Our reference: P-1182452-Y5J1
Contact: Sandra Fagan
Telephone: (02) 4732 7992

8 July 2026

Council Advice on the Environmental Impact Statement for SSD-98407710 - Aspect Industrial Estate Stage 6 Warehouse 4 at 788-882 Mamre Road, Kemps Creek

Project	ASPECT INDUSTRIAL ESTATE MAMRE ROAD, KEMPS CREEK LOT 4
Title	TYPICAL SITE SECTIONS SHEET 1

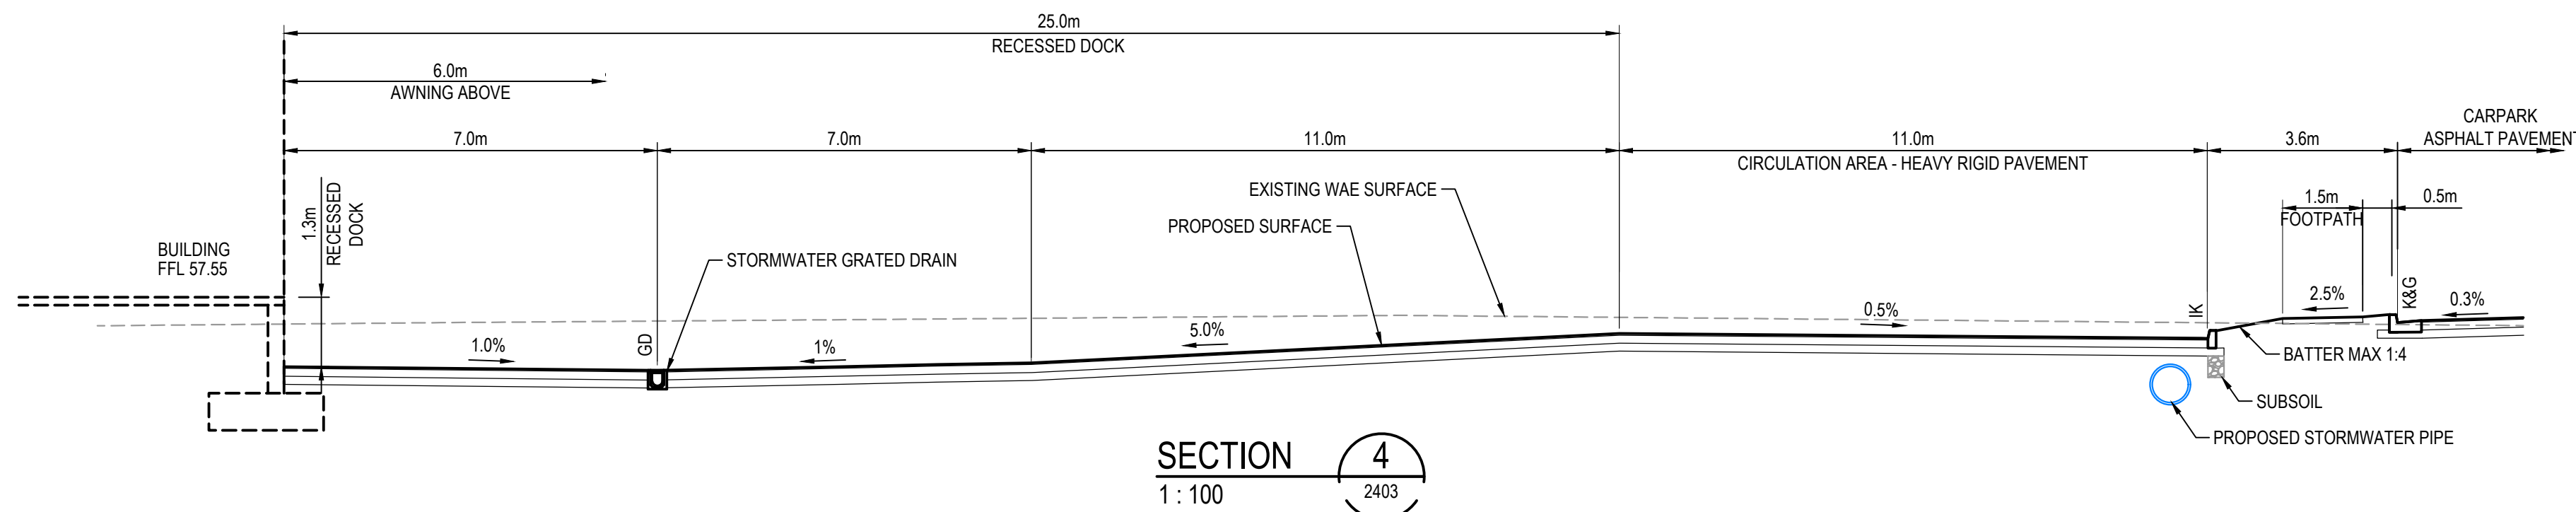
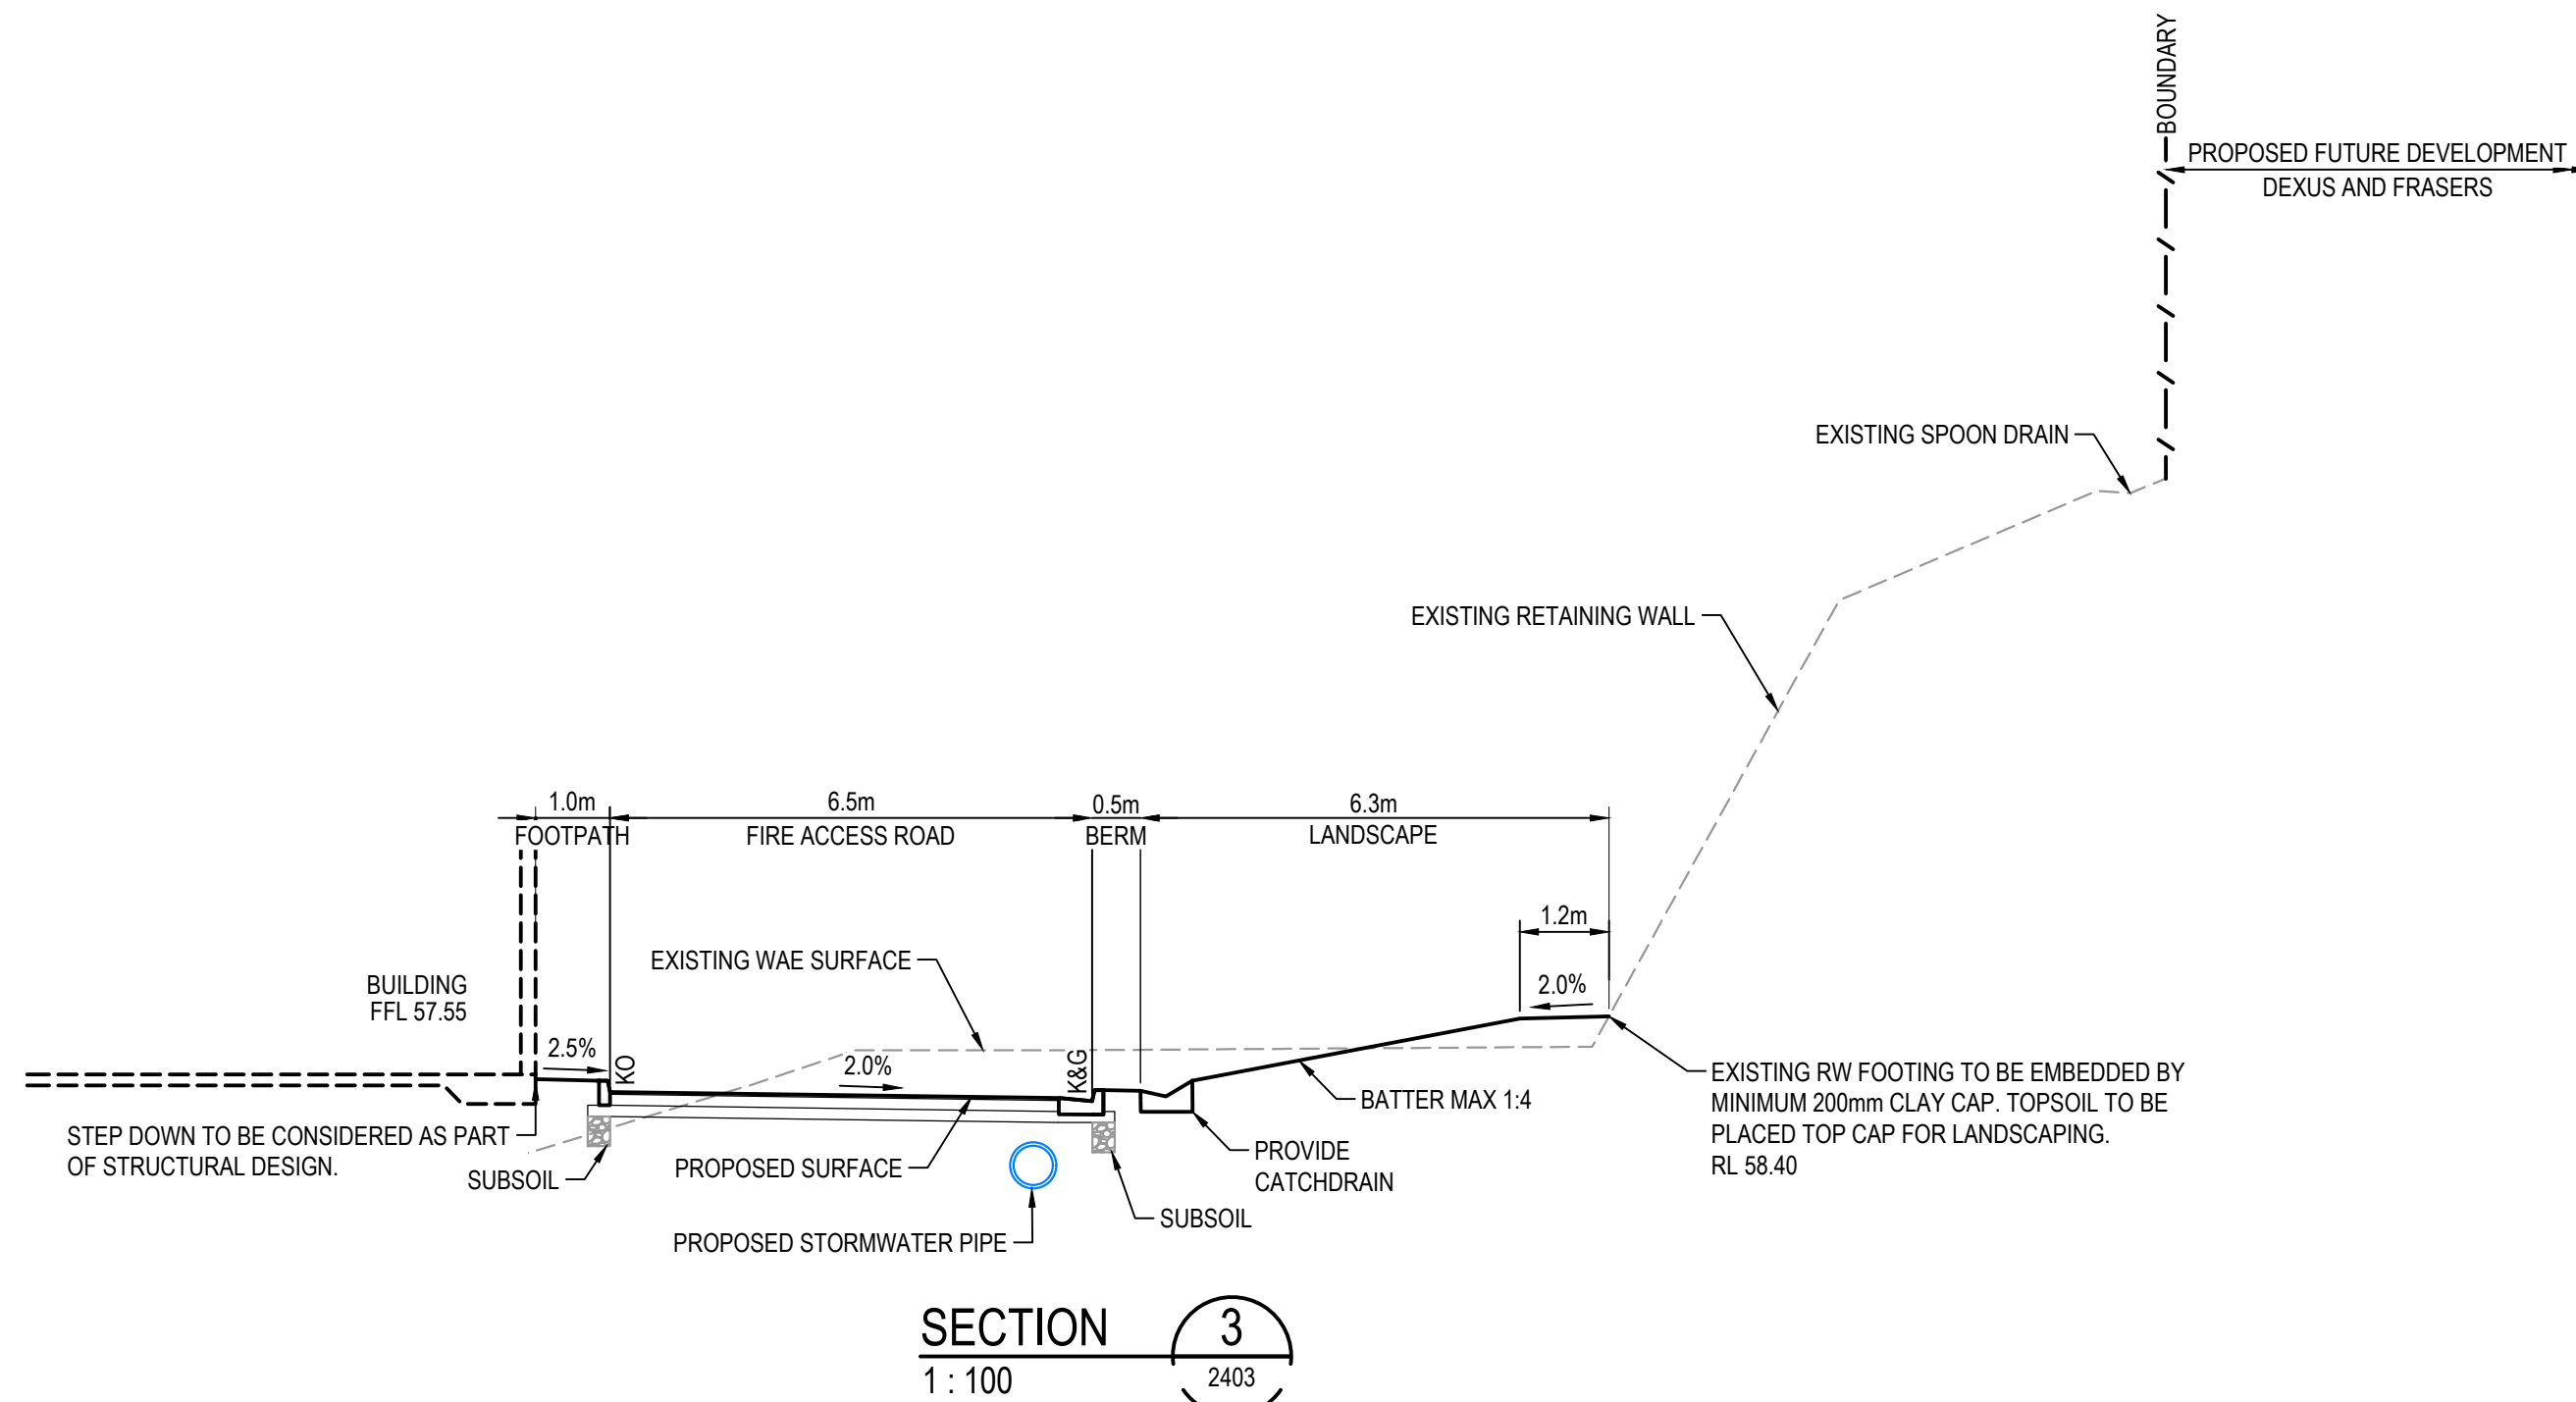
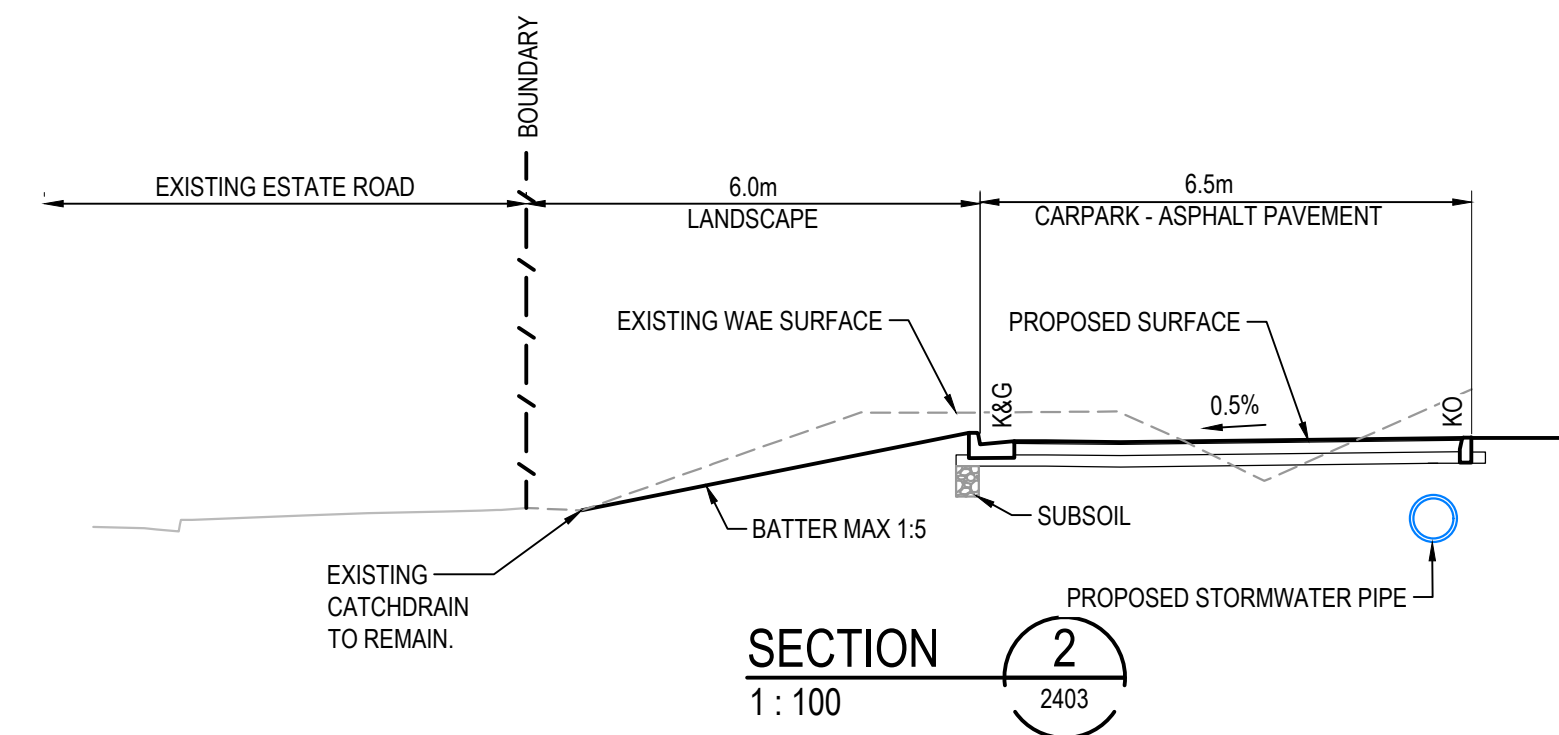
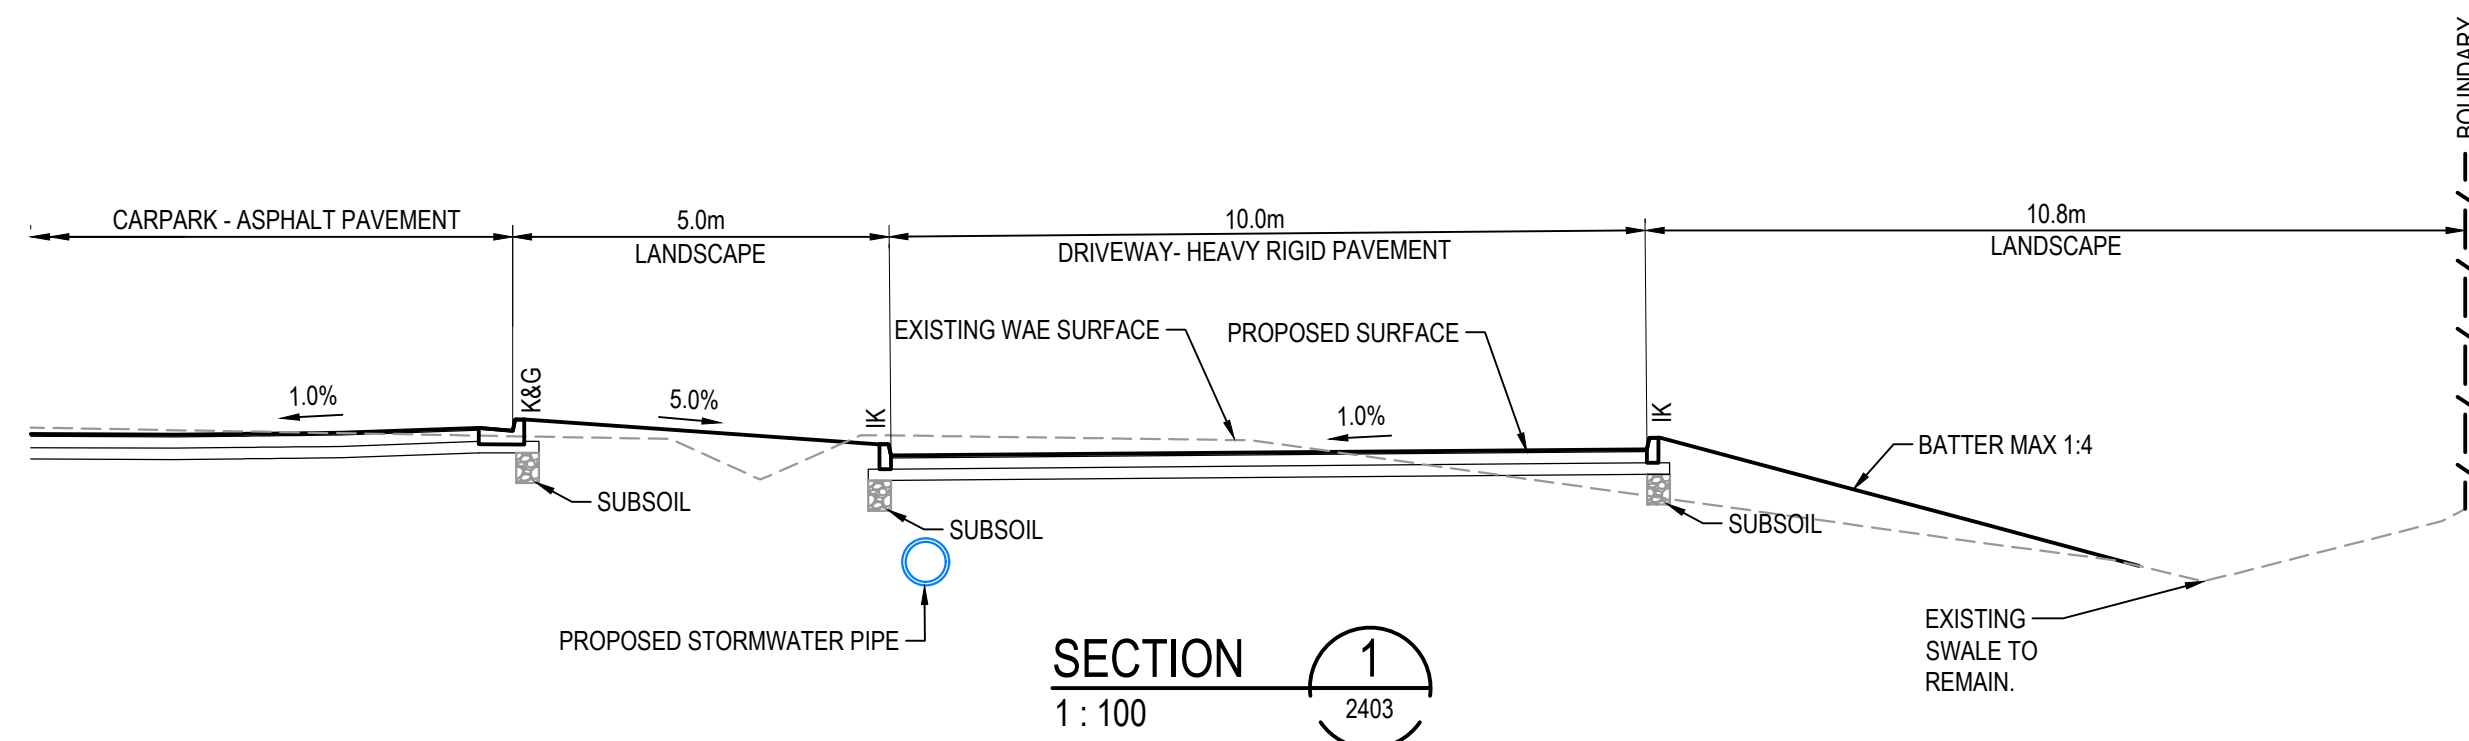
- g) The proposal includes new retaining walls fronting public roads. Such walls are to be compliant with the MRP DCP in relation to position, height, and potential need for tiering. Consideration must be given to the ability to provide meaningful landscaping within the landscaped setbacks where retaining walls are existing or proposed. Specifically, the proposed retaining wall adjoining the round-about should be screened by appropriate deep soil

landscaping. The civil drawings should include detailed sections through proposed retaining walls to show landscaping detail and feasibility.
